Non-Material Amendment

Description	Land adjacent 29 River Lane, Moulton
-------------	---

Erection of dwelling - outline approval H13-1069-16 allowed on appeal

Reference number:	H13-1215-17
Date of decision	20/02/2018

Drawn:	Checked:	Date:	Scale:	Page:
AMW	AMW	22.12.17	As shown	A1
Job No.:	Draw No.:	Stage:	Revision:	
081701	PD03	Planning	P2

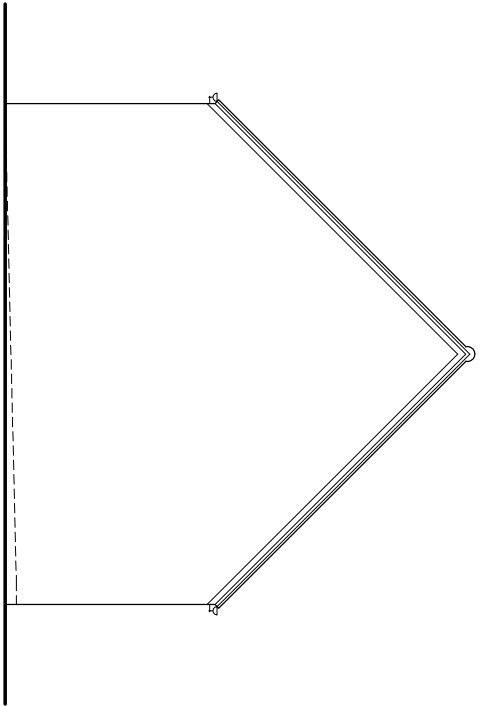
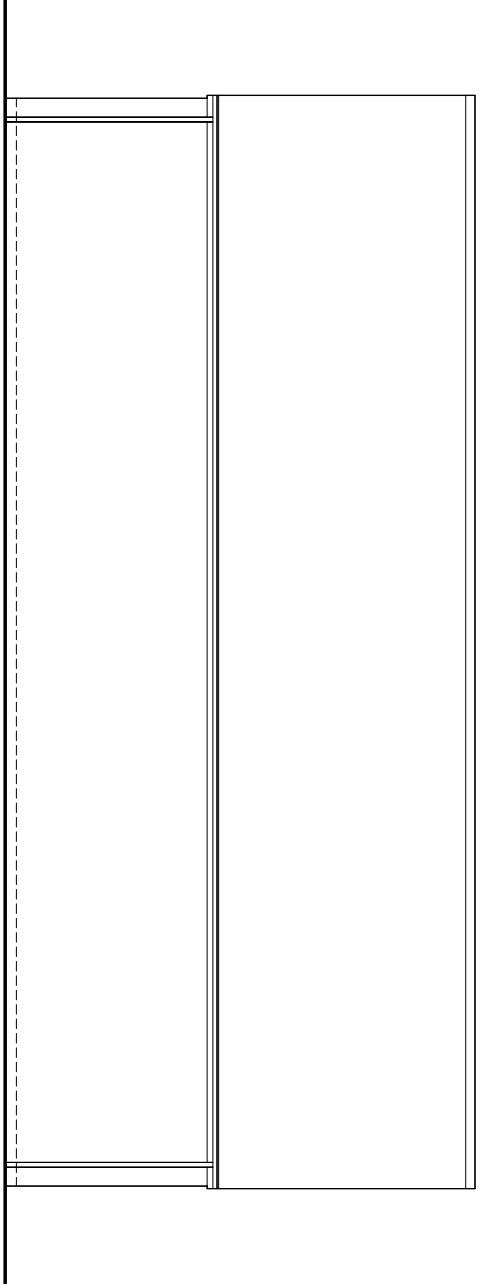
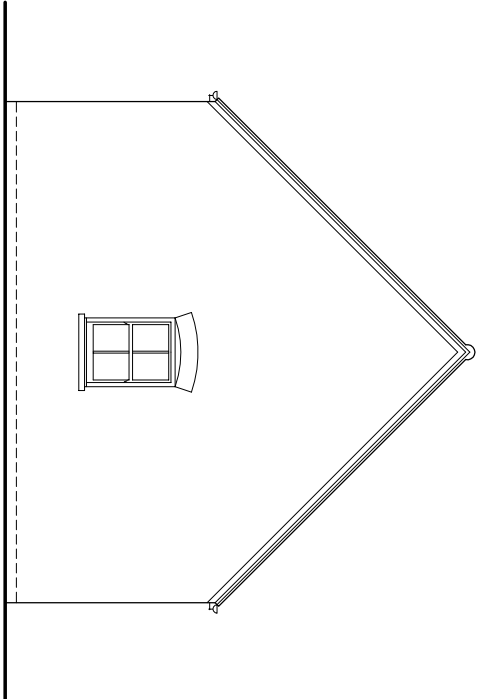
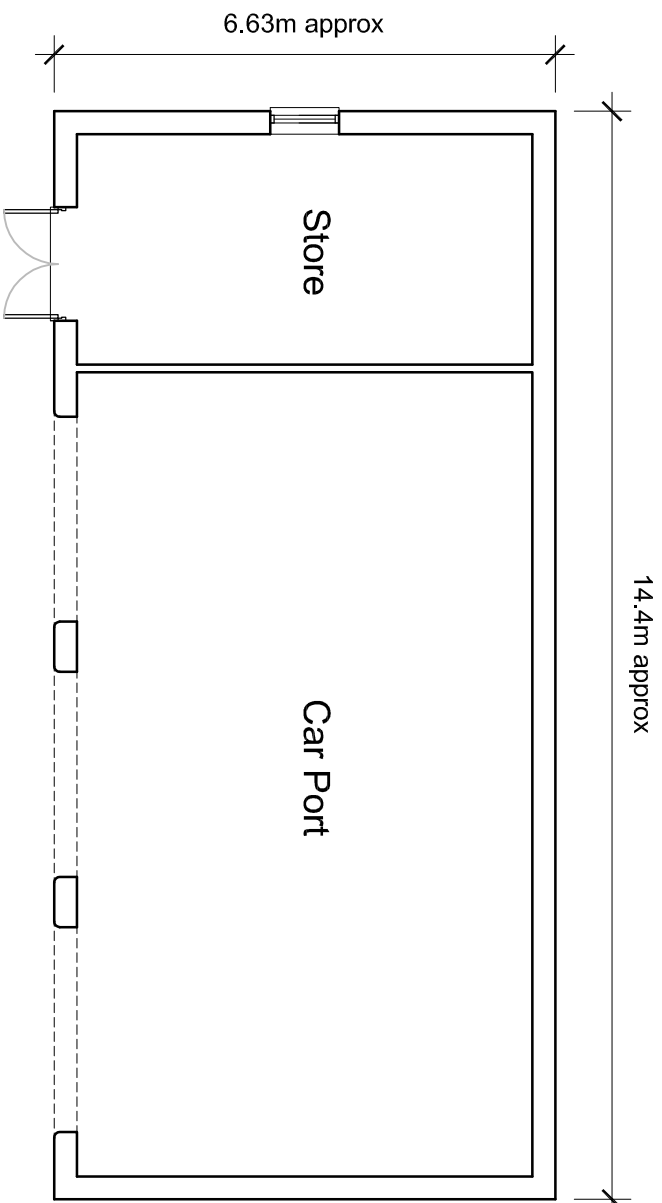
Brick type shown in Legend of drawings.
Changed to 'Imperial Handmade Bricks - Farm House Orange'.

PD03(P1) & PD04(P1)

PD03(P2) & PD04(P2)

The applicant has chosen a different brick type.
